Acela Number	
2019-170	1- Fire hydrant shall be located within 750' to the most remote point of building as truck travel for all buildings. 2- For non-sprinkled buildings. Fire department must be able to reach all
2019-171	No Comments. Rezoning request.
2019-172	No Comments. Rezoning request.
2019-173	No Comments. Rezoning request.
2019-174	1- Fire hydrant shall be located within 750' to the most remote point of building as truck travel for all buildings. 2- For non-sprinkled buildings. Fire department must be able to reach all exterior portion of building within 150' from access road. 3- For sprinkled buildings. Fire department must be able to reach all exterior portion of building within 200' from access road. 4- For buildings that is equipped with a sprinkler system. A fire department connection shall be
2019-175	1-Fire department access road shall have a min. 20' unobstructed clear width and shall be capable of supporting 80,000 lbs. 2- Fire hydrant shall be located within 750' to the most remote point of building as truck travel for all buildings. 3-Turn radius 30' inside and 42' outside. 4-For buildings that is equipped with a sprinkler system. A fire department connection sh

RZ-1

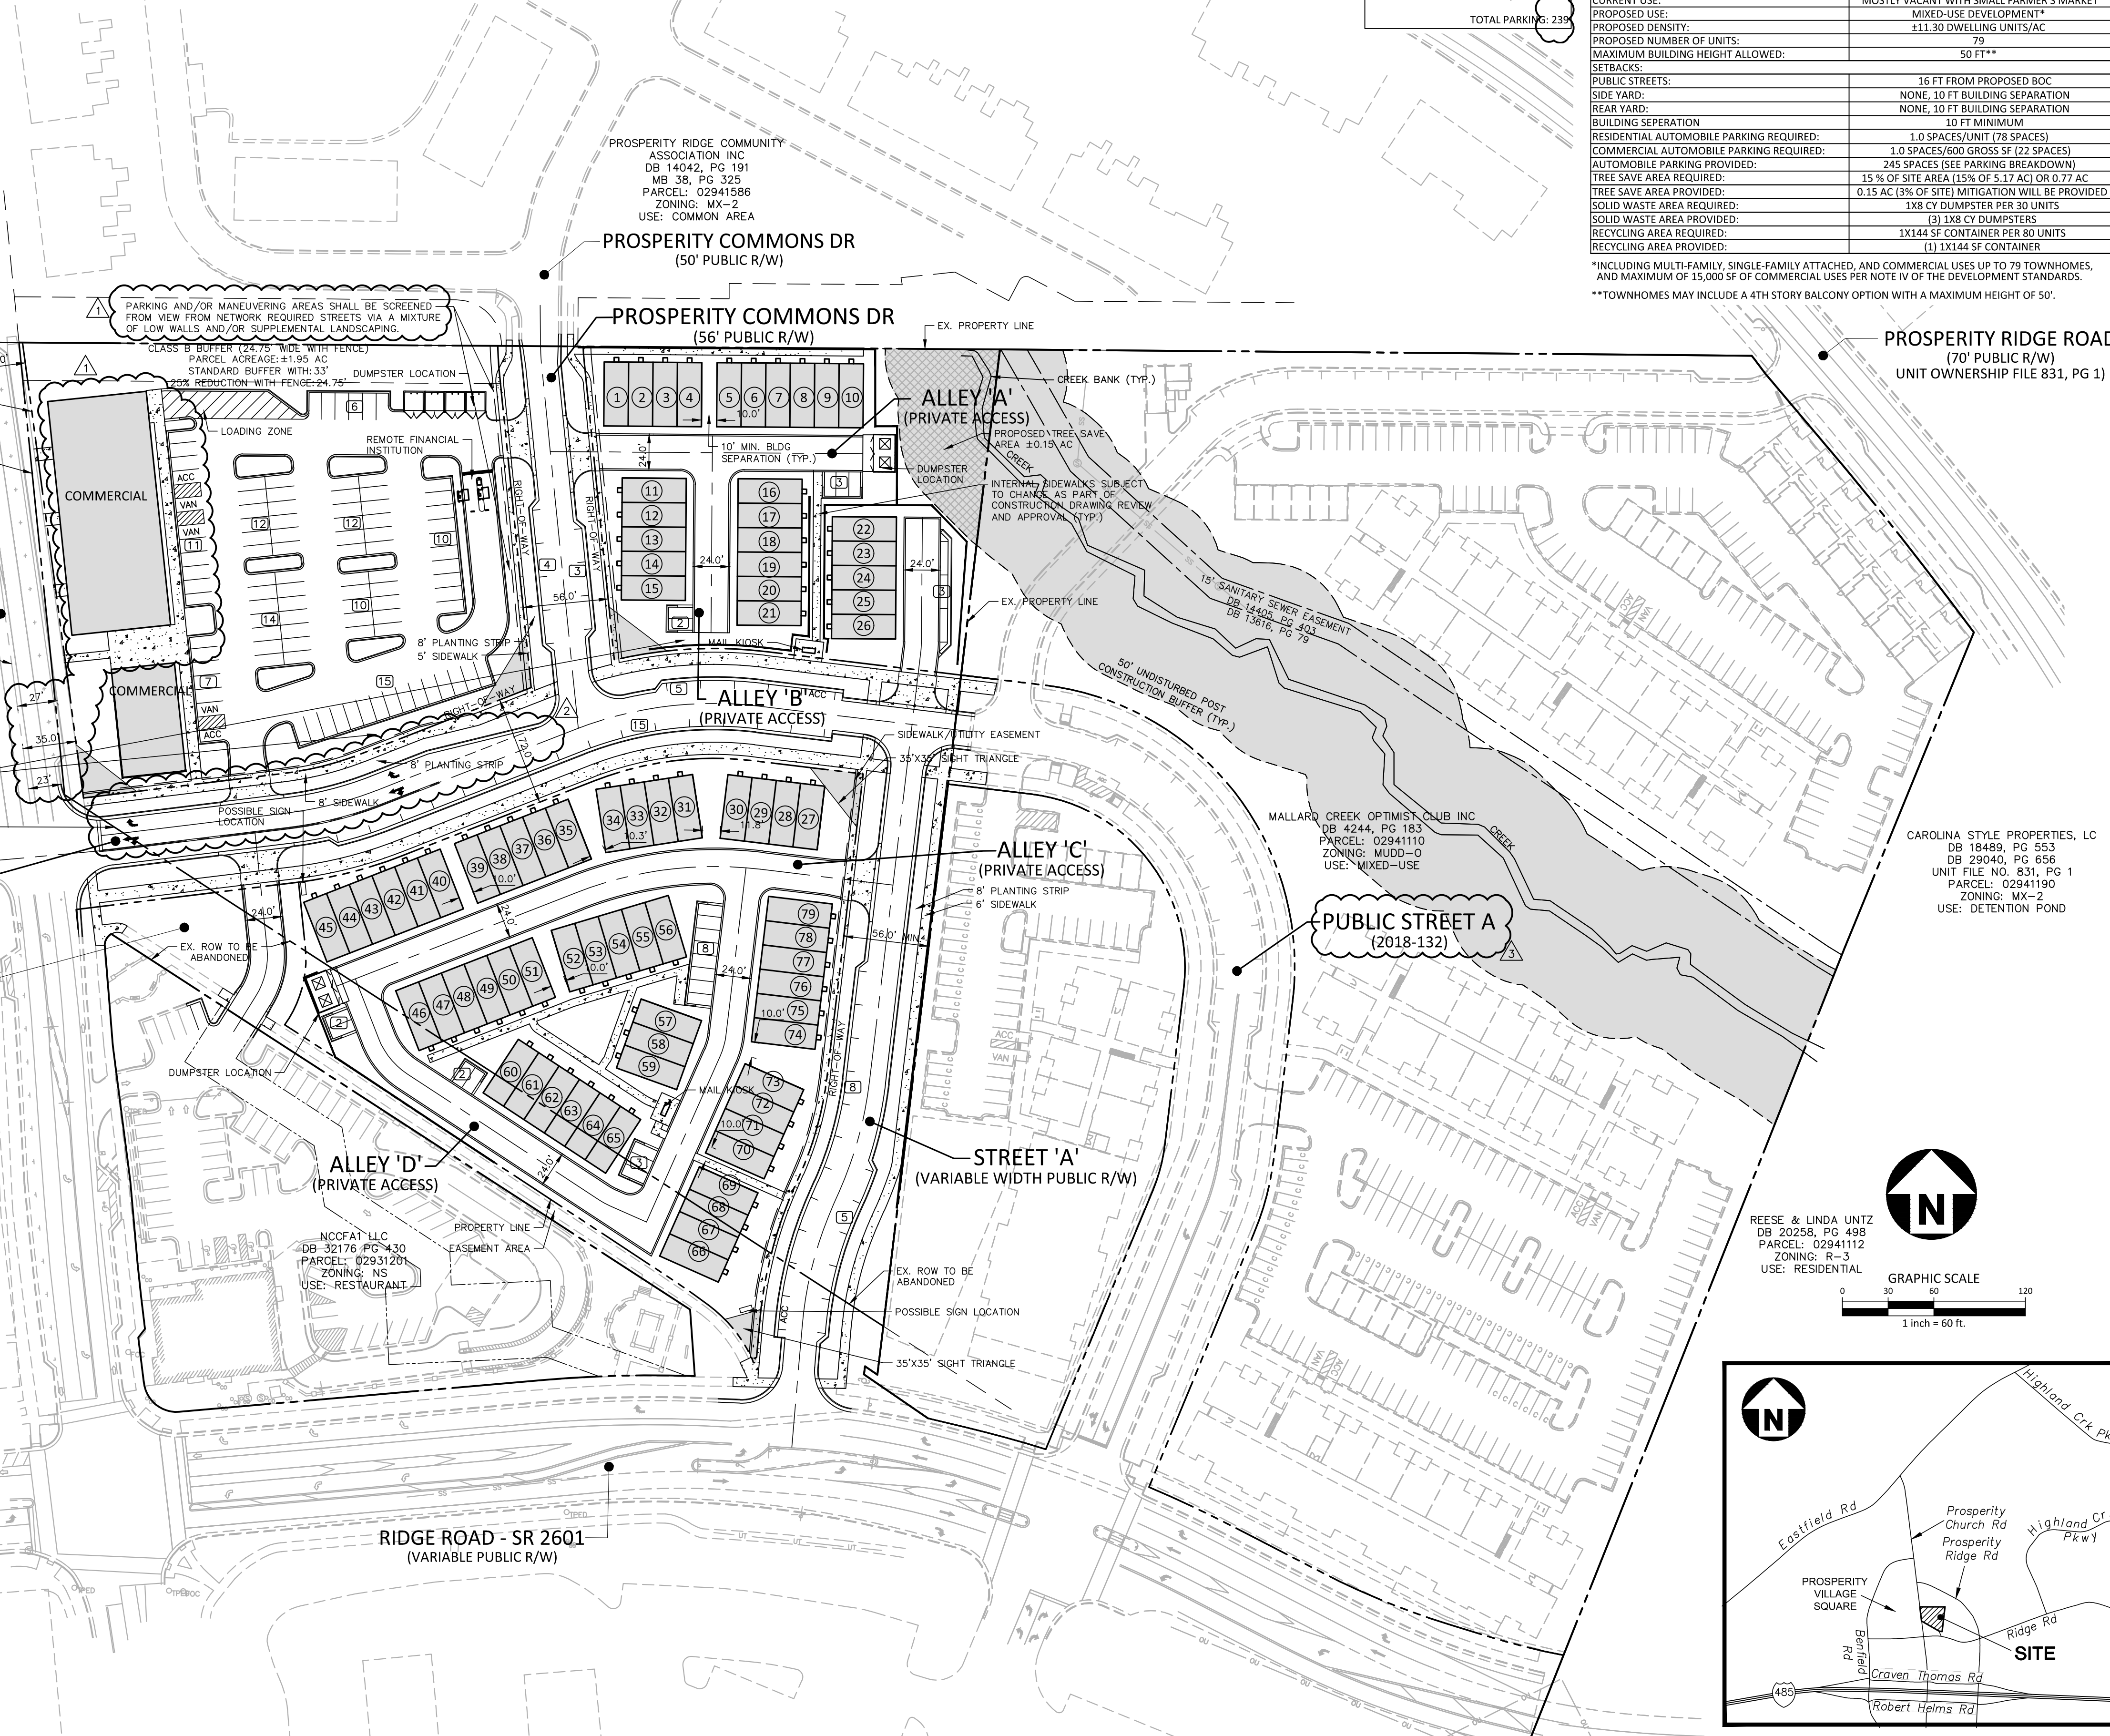
2019-177	capable of supporting 80,000 lbs. 2- Turn radius 30' inside and 42' outside. 3- Fire hydrant shall be located within 750' to the most remote point of building as truck travel for all buildings.
2019-178	1- Fire department access road shall have a min. 20' unobstructed clear width and shall be capable of supporting 80,000 lbs. 2- Fire department access road that exceeds 150' shall provide an approved turnaround. 3- Turn radius 30' inside and 42' outside. 4- Fire hydrant shall be located within 750' to the most remote point of building as truck travel for all buildings. 5- For
2019-179	1- Fire department access road shall have a min. 20' unobstructed clear width and shall be capable of supporting 80,000 lbs. 2- Fire department access road that exceeds 150' shall provide an approved turnaround. 3- Fire hydrant shall be located within 750' to the most remote point o
2019-180	1- Fire department access road shall have a min. 20' unobstructed clear width and shall be capable of supporting 80,000 lbs. 2- Fire department access road that exceeds 150' shall provide an approved turnaround. 3- Turn radius 30' inside and 42' outside. 4- Fire hydrant shall be located within 750' to the most remote point of building as truck travel for all buildings. 5- For non-sprinkled buildings. Fire department must be able to reach all exterior portion of building within 150' from access road. 6- For sprinkled buildings. Fire department must be able to reach
